From: Duncan Bremer <duncan.bremer@gmail.com>
Sent: Tuesday, July 30, 2024 10:19
To: Steve Jacobs; Jacobs, Stephen; Wayne M Timura; Gorman, David; Brian Frantz
Subject: Fwd: Eagle Rising Filing No. 1 - Basic Issues for Resolution

From: **Meggan Herington** <MegganHerington@elpasoco.com>
Date: Mon, Jul 29, 2024 at 5:26 PM
Subject: RE: Eagle Rising Filing No. 1 - Basic Issues for Resolution
To: Duncan Bremer <duncan.bremer@gmail.com>
Cc: Ryan Howser <RyanHowser@elpasoco.com>, Justin Kilgore <JustinKilgore@elpasoco.com>, Kenny Hodges <KennyHodges@elpasoco.com>

Subject: Eagle Rising Filing No. 1 - Basic Issues for Resolution

**EAGLE RISING FILING NO. 1**  
 A PORTION OF THE EAST HALF (E 1/2) OF SECTION 29, TOWNSHIP 12 SOUTH,  
 RANGE 65 WEST OF THE SIXTH PRINCIPAL MERIDIAN, EL PASO COUNTY, COLORADO

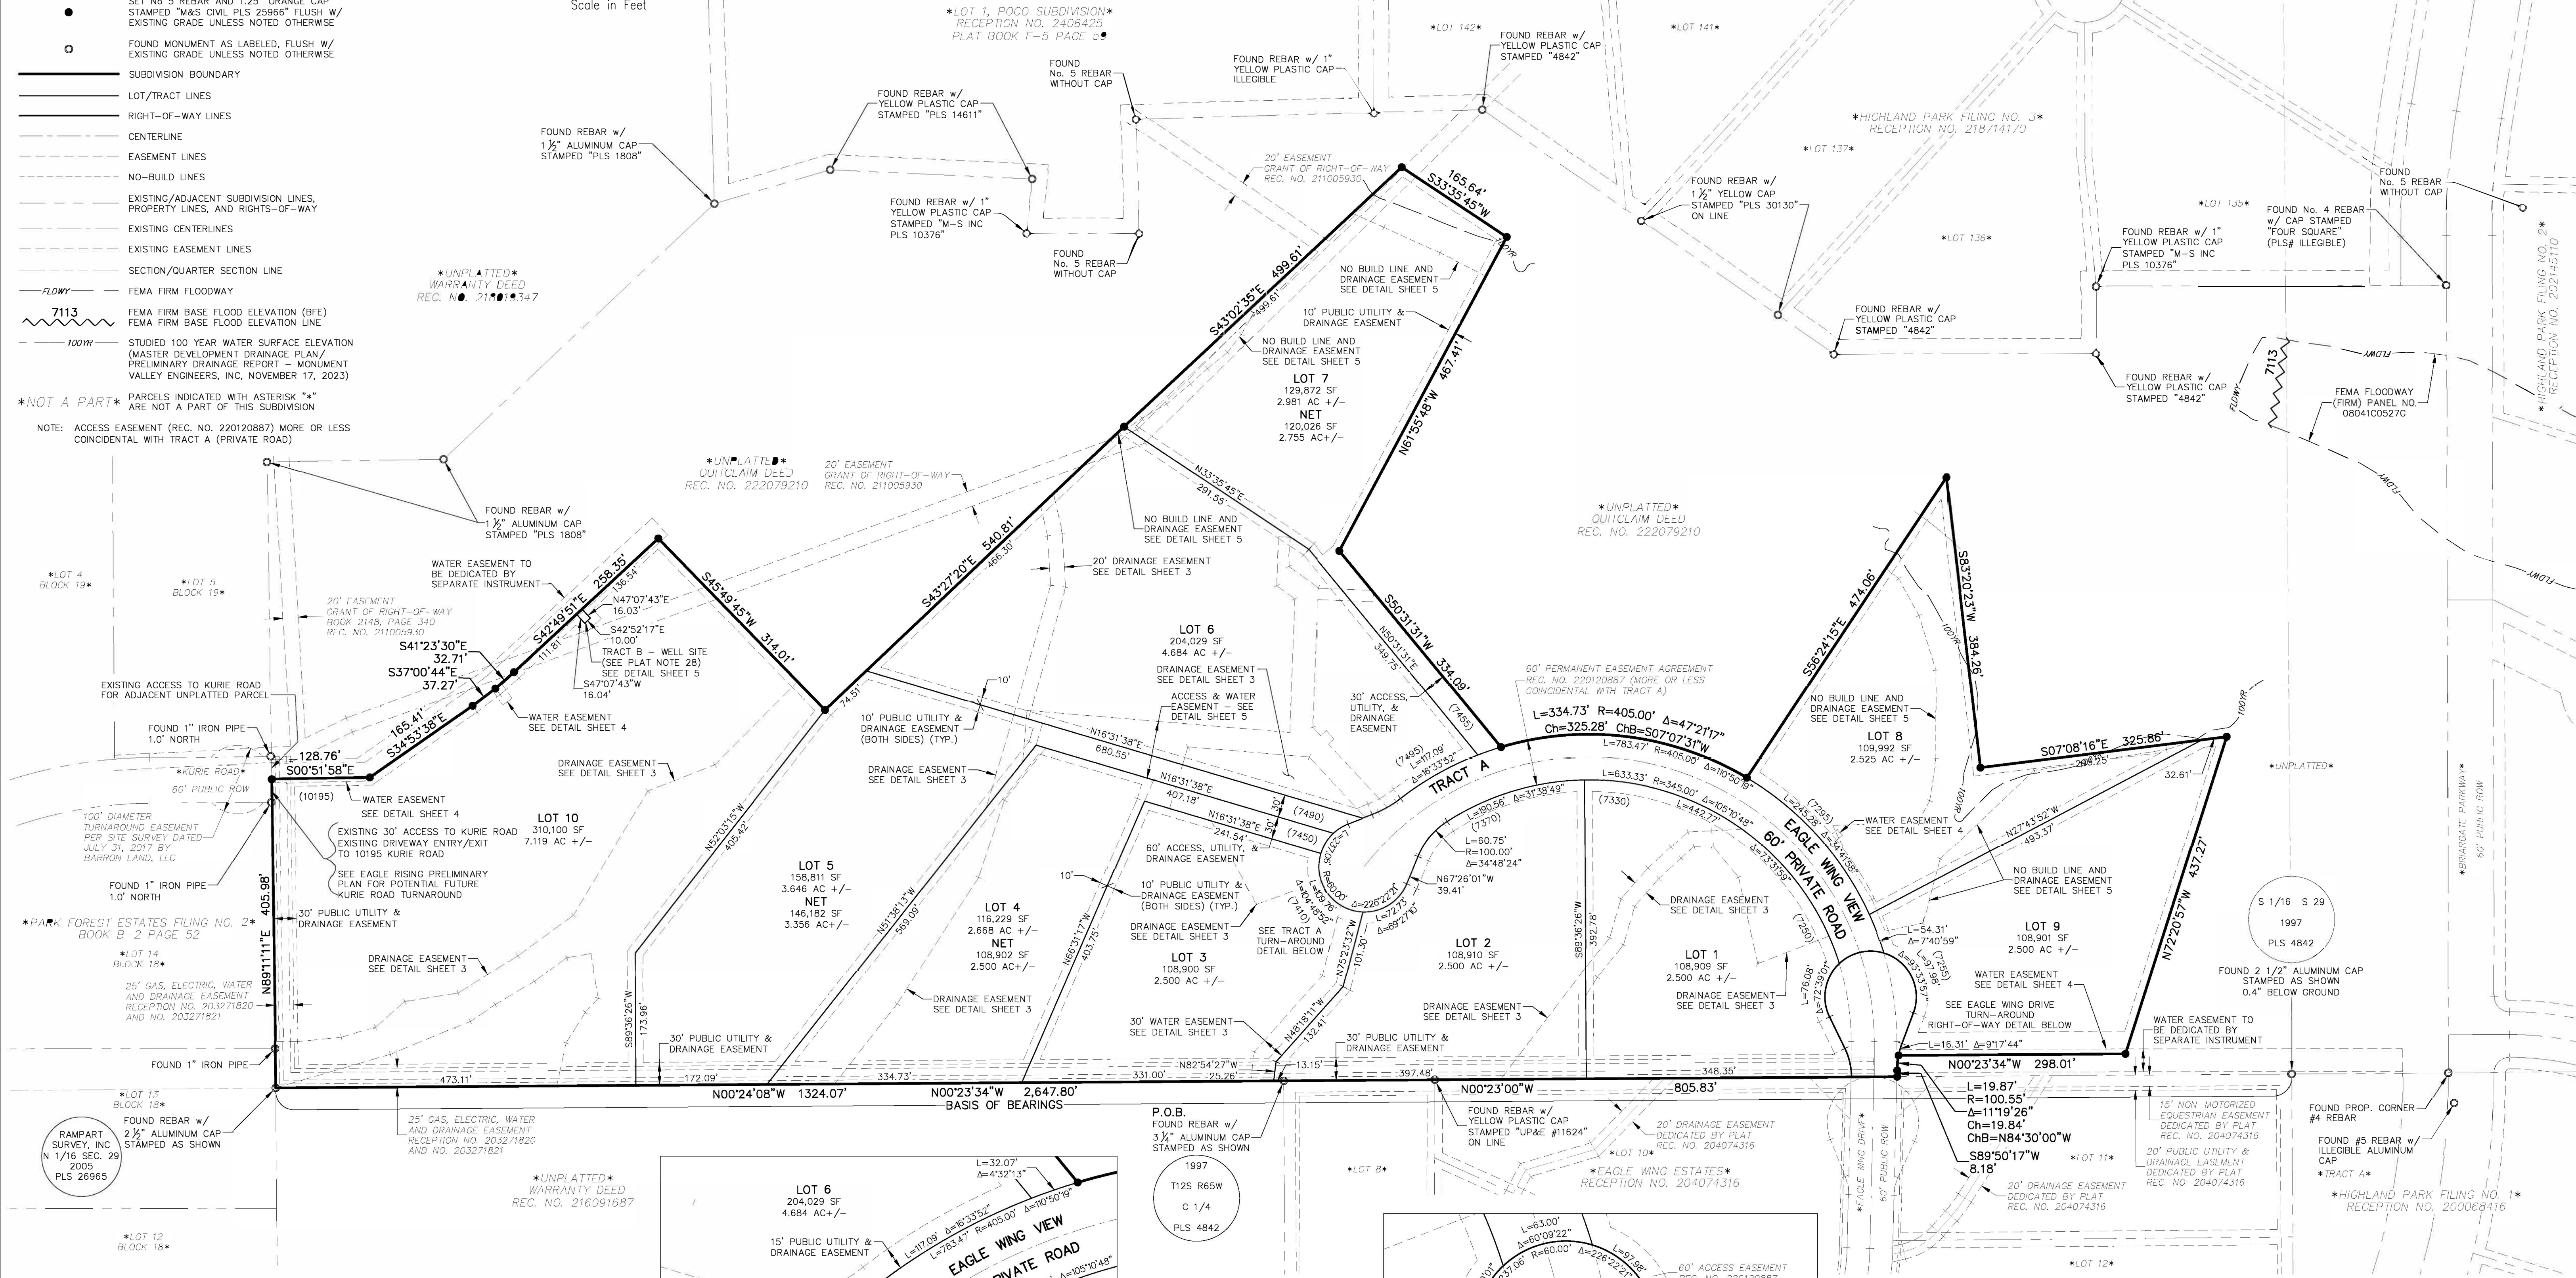
The other major issue we have been wrestling with is what to do about the turnaround shown on the Preliminary Plan as the extension of Kurie Road. I am sure you agree that the purpose of the turnaround is to permit the four lots shown on the Preliminary Plan to each have the required 30-foot frontage on Kurie Road. Eagle Rising Final Plat Filing No. 1 has only one lot accessing Kurie Road with its existing driveway, and we all agree Lot 10 has 30 feet of frontage and access on Kurie Road. There is no need for the Applicant to build or dedicate the land for the turnaround in Eagle Rising Final Plat Filing No. 1 where only one lot is platted with frontage and access off Kurie Road.

The Applicant is fully aware of the turnaround in the Preliminary Plan and if required in the future and will note this on the Eagle Rising Final Plat Filing No. 1.. However, the Applicant does not understand the need at this time to put any land at this location into a tract, removing it from Lot 10, and thus reducing the value of Lot 10. This is the issue we need to solve.

Option 1 - Put the right-of-way in a tract and include a tract table on the plat that states this tract will be owned by the HOA and the future intended use is public right-of-way for Kurie Road. We can discuss the specific language if you are uncomfortable using the term "reservation". Or,

Option 2 - Dedicate all or a determined portion of the Kurie Road right-of-way as public road right-of-way. No construction of the road is required at this point, just dedication or reservation of the right-of-way.

We could draft a note for the plat that acknowledges that it will take agreement between the owner of Lot 10, Filing No. 1 and the owner of the land to the east in order to accomplish the turnaround shown on the approved Preliminary Plan, if and when the landowners desire it.

**STUDIED 100 YEAR WATER SURFACE ELEVATIONS  
 NO-BUILD LINE AND DRAINAGE EASEMENT DETAIL**  
 LOTS 8 & 9  
 SCALE: 1" = 50'

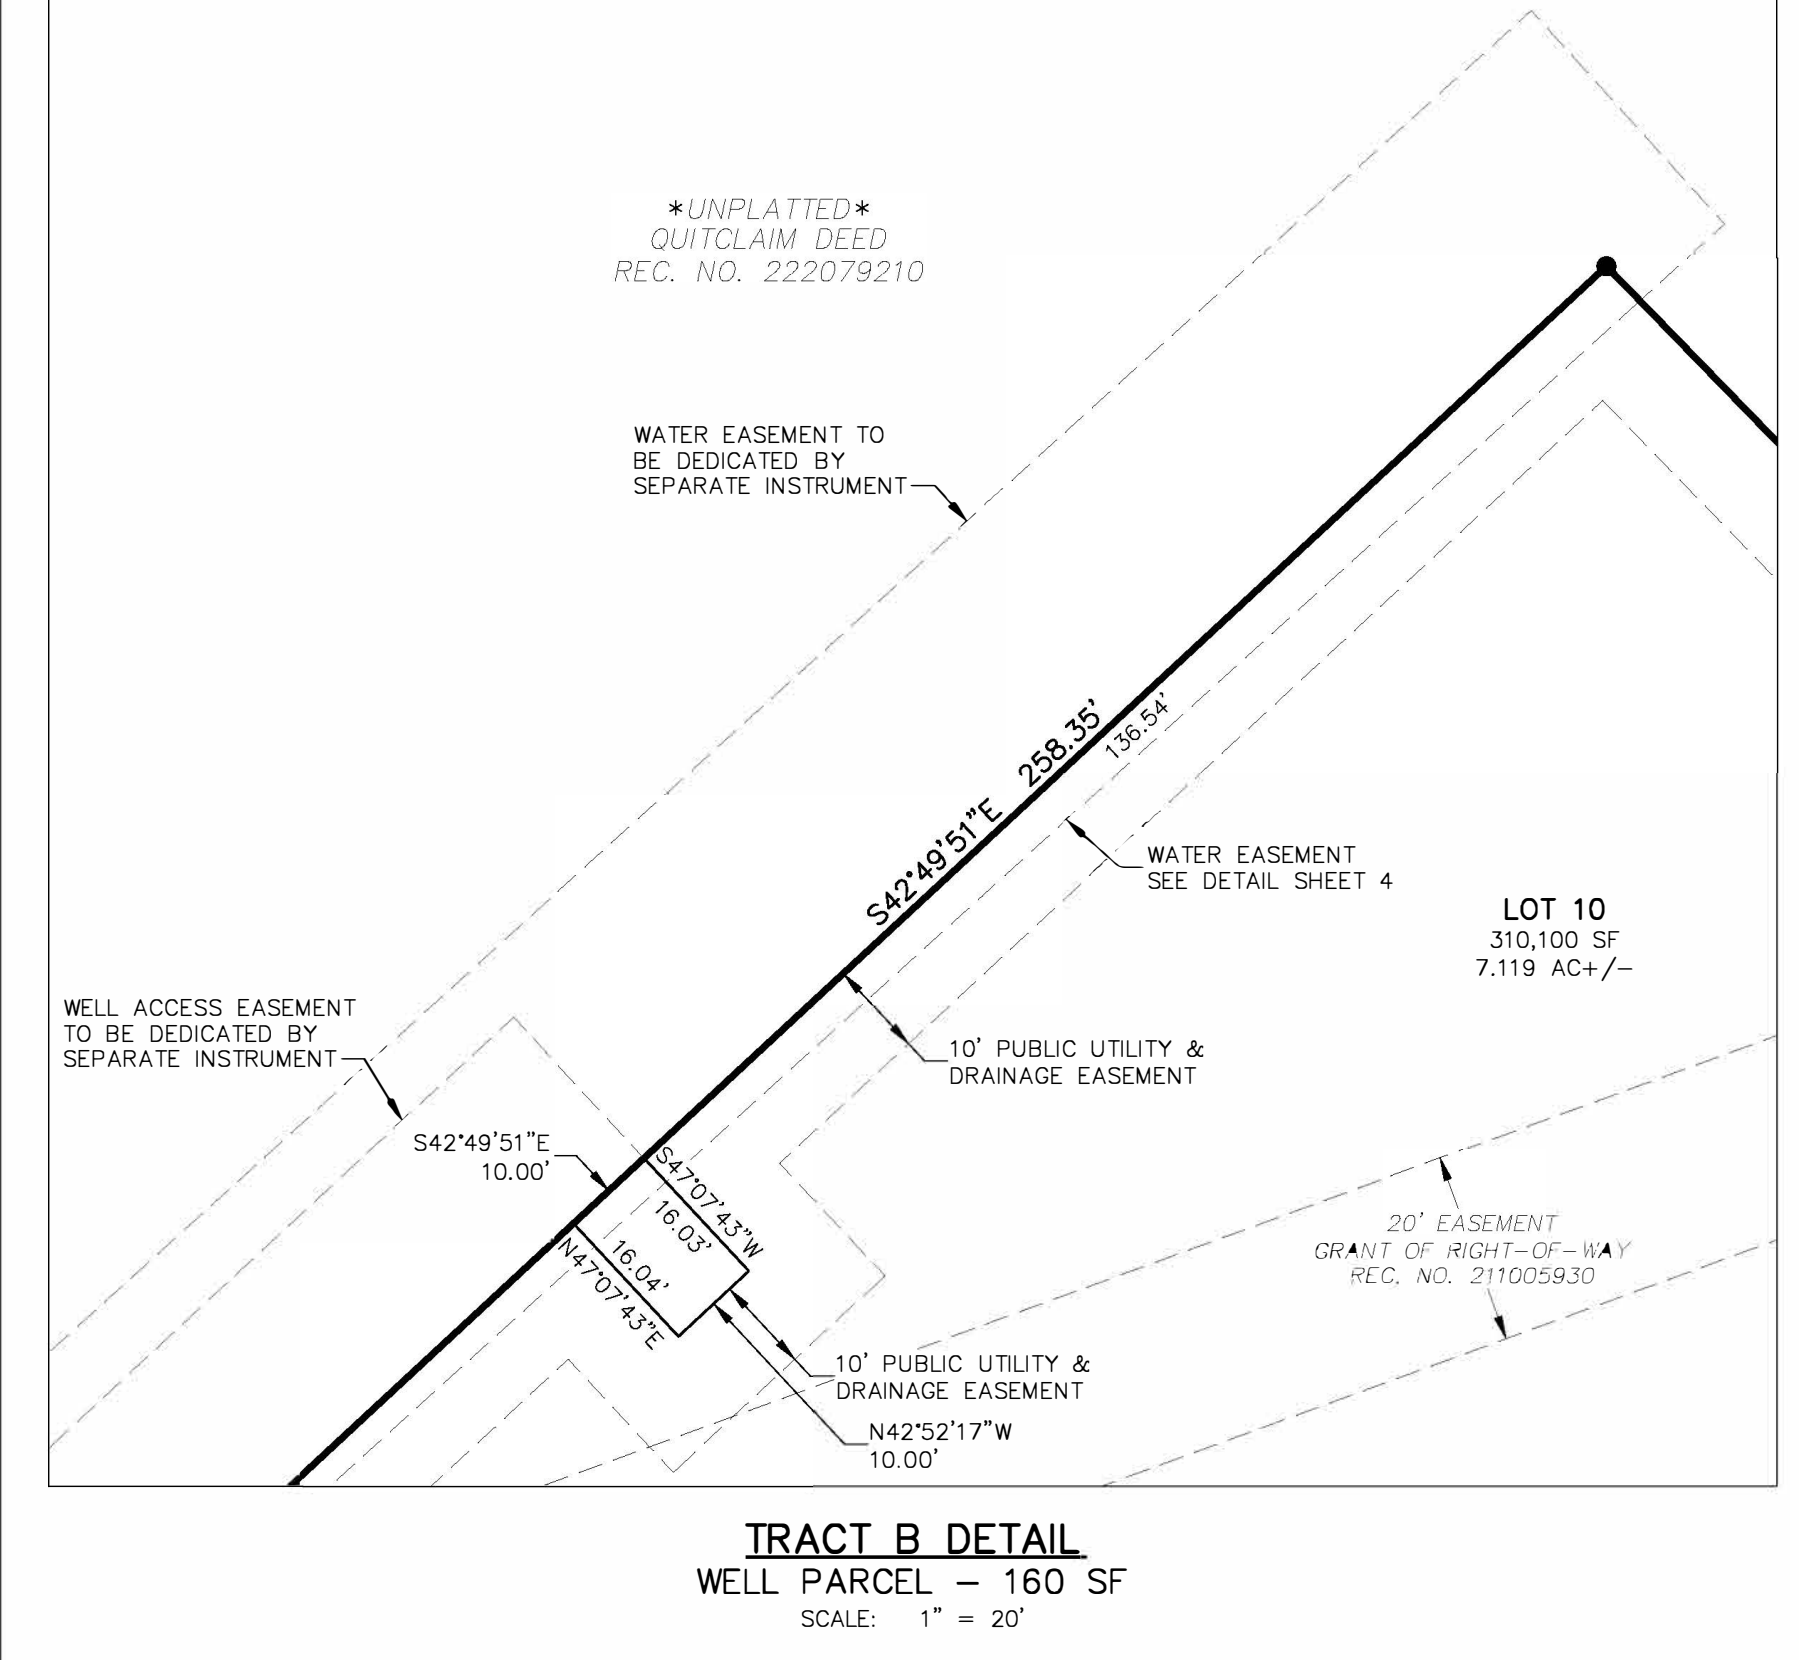
Duncan, the requirement from the last meeting was that the lots had to be out of the 100-year floodplain plus 15 feet for maintenance unless the current owner still wants an agreement allowing others to access a 15-foot easement on the two lots in question. This is an engineering item and I'm relaying what staff has told me is needed to meet the requirements of the ECM.

The Eagle Rising Final Plat Filing No. 1 Applicant has followed your suggestion and is removing all lots from the 100-year flood limit as established in the approved drainage documents. As you stated, with this accomplished, it should remove the need for a drainage maintenance agreement. That issue will be dealt with when the land to the east is platted. Since accomplishing this involves considerable costs, please confirm this approach satisfies your Option 2 "Pull all lots in the first filing out of the channel area. Then

Option 1 – Per the approved deviation that allows no channel improvements, submit the agreements for the maintenance of wetlands vegetation. The deviation approval is contingent upon having this maintenance agreement in place.

Option 2 – Pull all lots in the first filing out of the channel area. Then all requirements will be implemented with the next phase or filing that impacts the channel.
